Ribble Valley Borough Council
Council Offices
Church Walk,
Clitheroe
Lancashire
BB7 2RA

Phone: 0300 123 6780
Email: developeras@lancashire.gov.uk
Your ref: 3/2026/0446
Our ref: 3/2026/0446/HDC/KW
Date: 22 July 2026

Location: Ribble Valley View Old Langho Road Langho BB6 8AW
Proposal: Proposed erection of 9 no. holiday lodges.
Grid Ref: 370040 435875

Lancashire County Council acting as the Local Highway Authority does not consider that the application as submitted fully assesses the highway impact of the proposed development and further information is required as set out in this response. Without this information the Local Highway Authority is unable to provide final highway advice on this application.

Proposed Site Plan - Positions for lodges 1-9

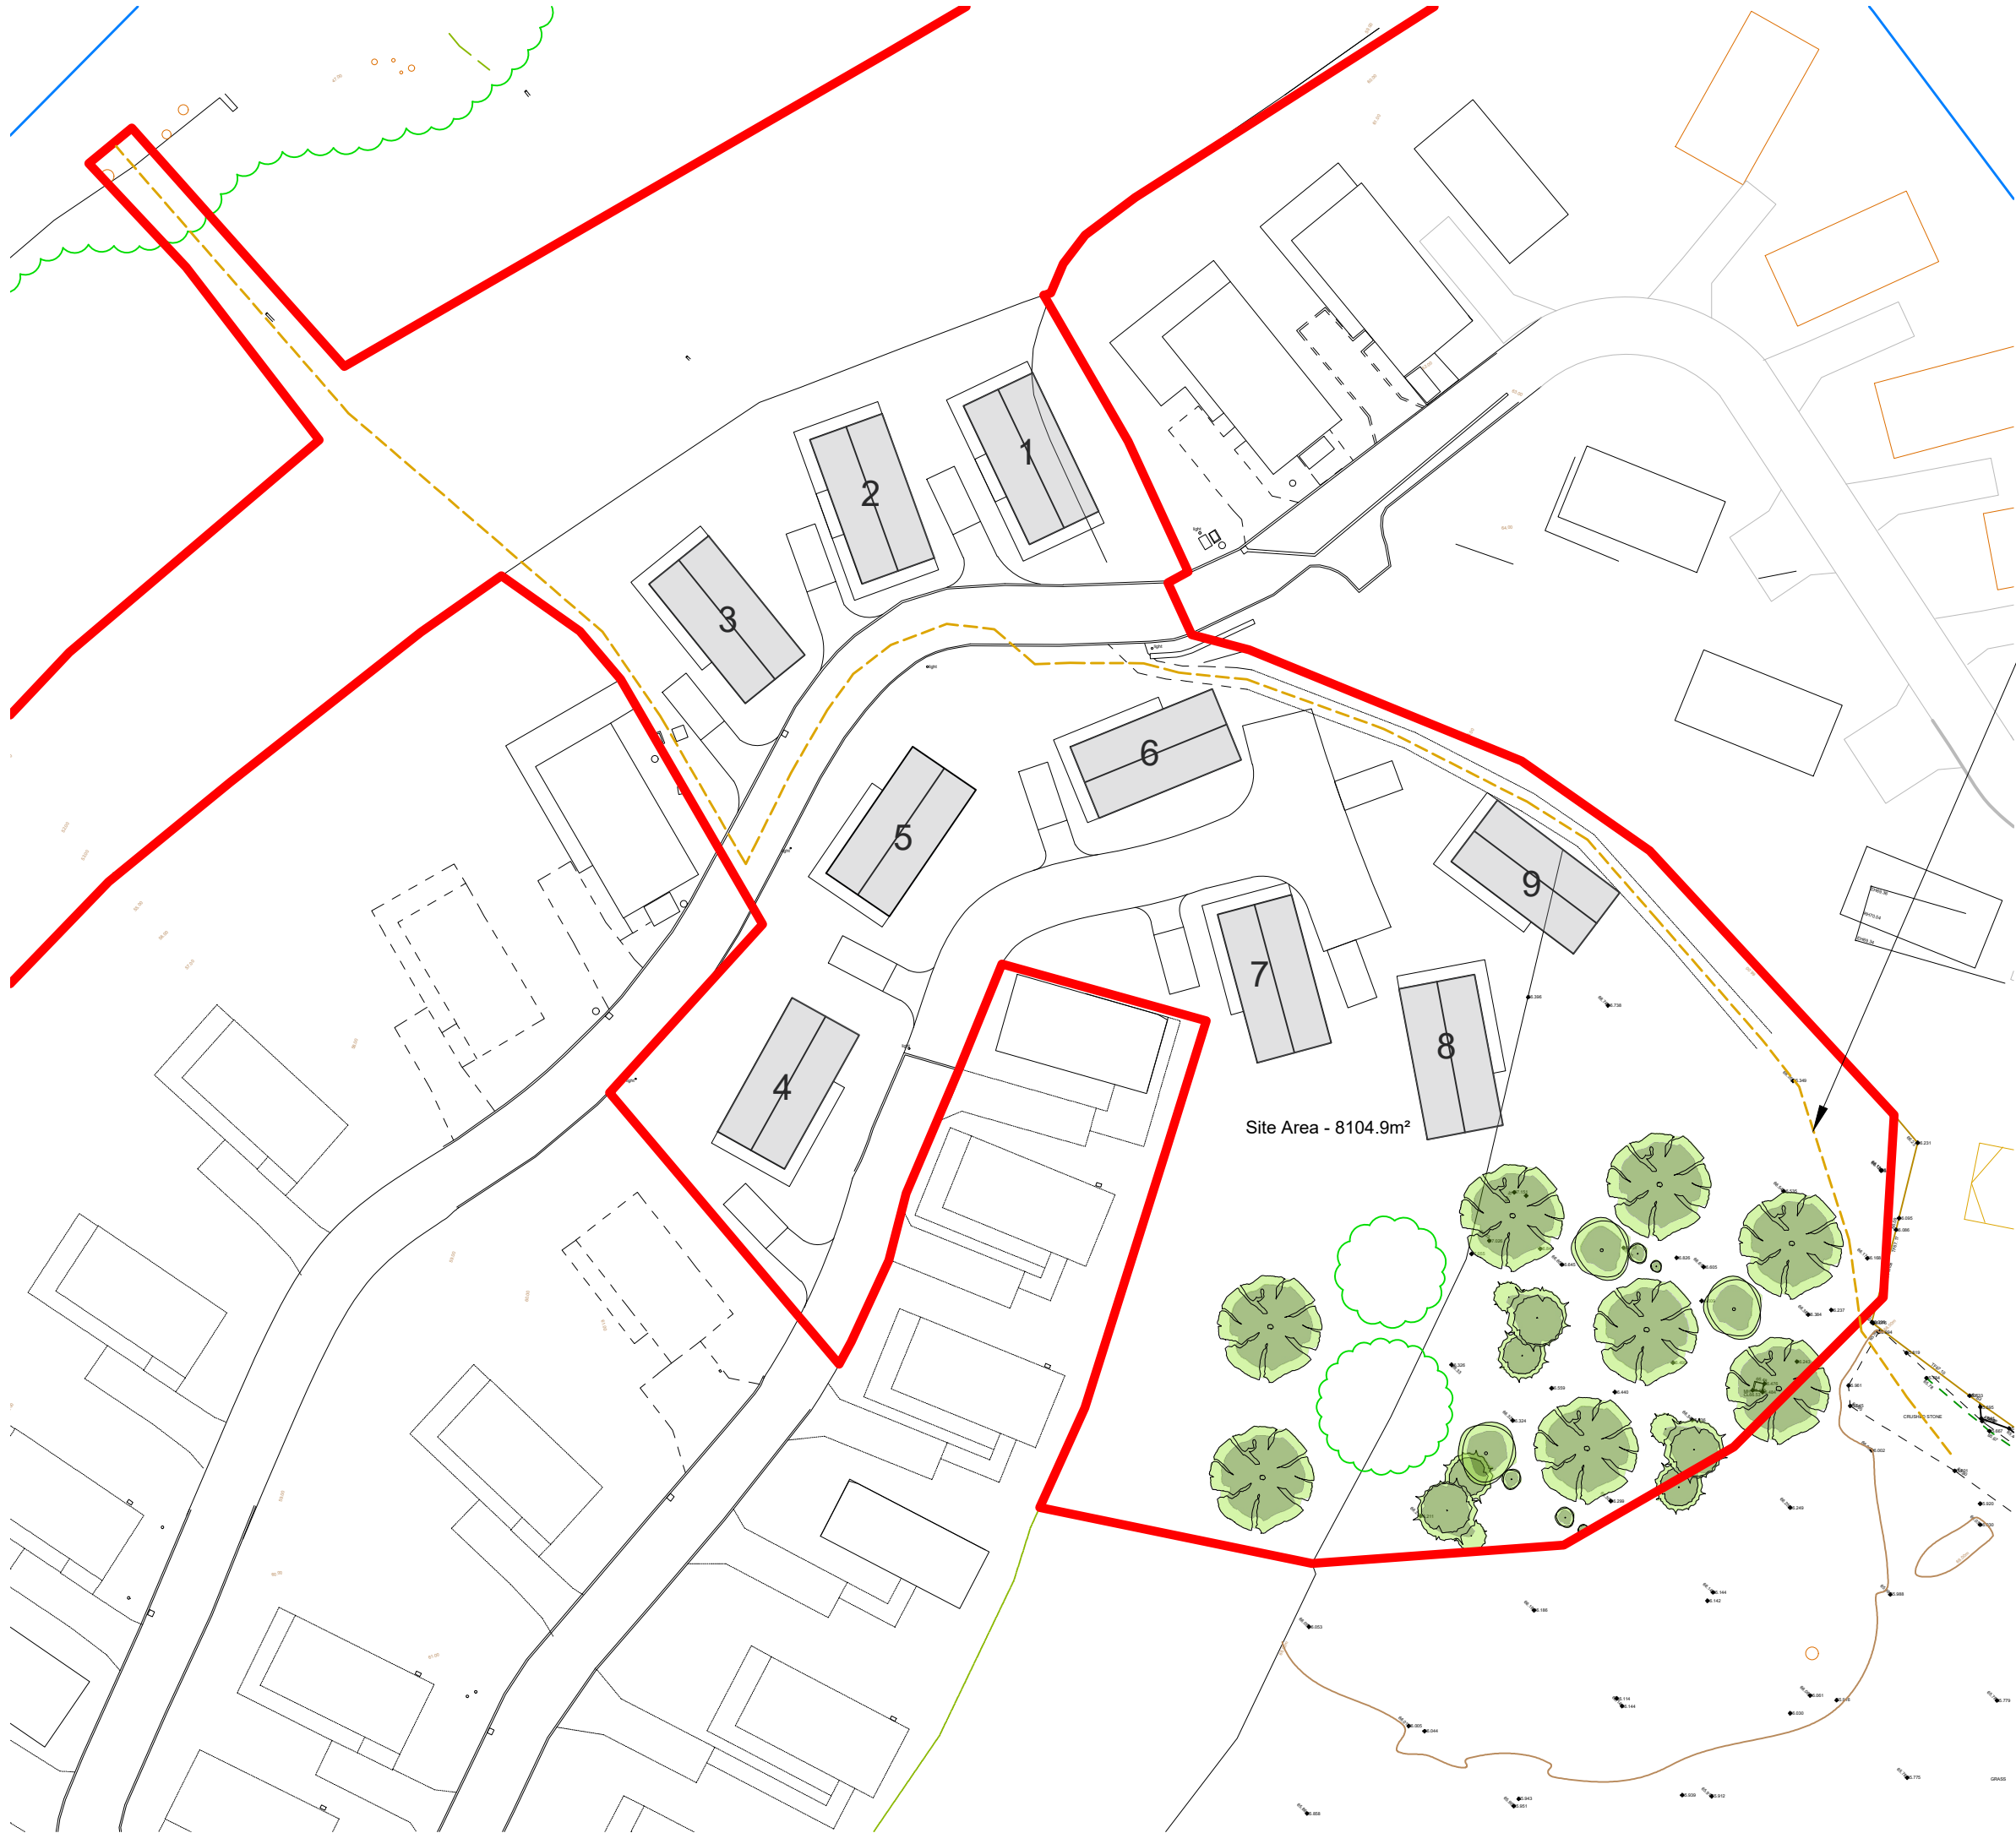
The LHA have reviewed drawing number SIMPS-01F Dwg 03 titled Proposed Site Plan - Positions for lodges 1-9 and understand that plots 1 – 3 will be placed adjacent to the existing internal road and a new internal road is proposed at the site which will provide access to plots 4 - 9. The width of the internal layout will remain similar to what already exists within the site, and a turning head is provided where the access road comes to an end.

The drawing also shows that a minimum of one car parking space for each holiday lodge will be provided at the site; however, the LHA understand from the submitted documents that the holiday lodges are proposed to be either 2 or three bedrooms, as such they should be provided with 2 off-street parking spaces. The LHA ask that this be amended to provide adequate parking provisions. These spaces should measure 2.4m x 5m; where they are adjacent to a fence or similar obstruction, an additional width of 0.6m should be provided.

In order to progress this application, the applicant is required to review the parking provisions within the site and increase the provisions to at least 2 off street parking spaces for each lodge which has 2-3 bedrooms.
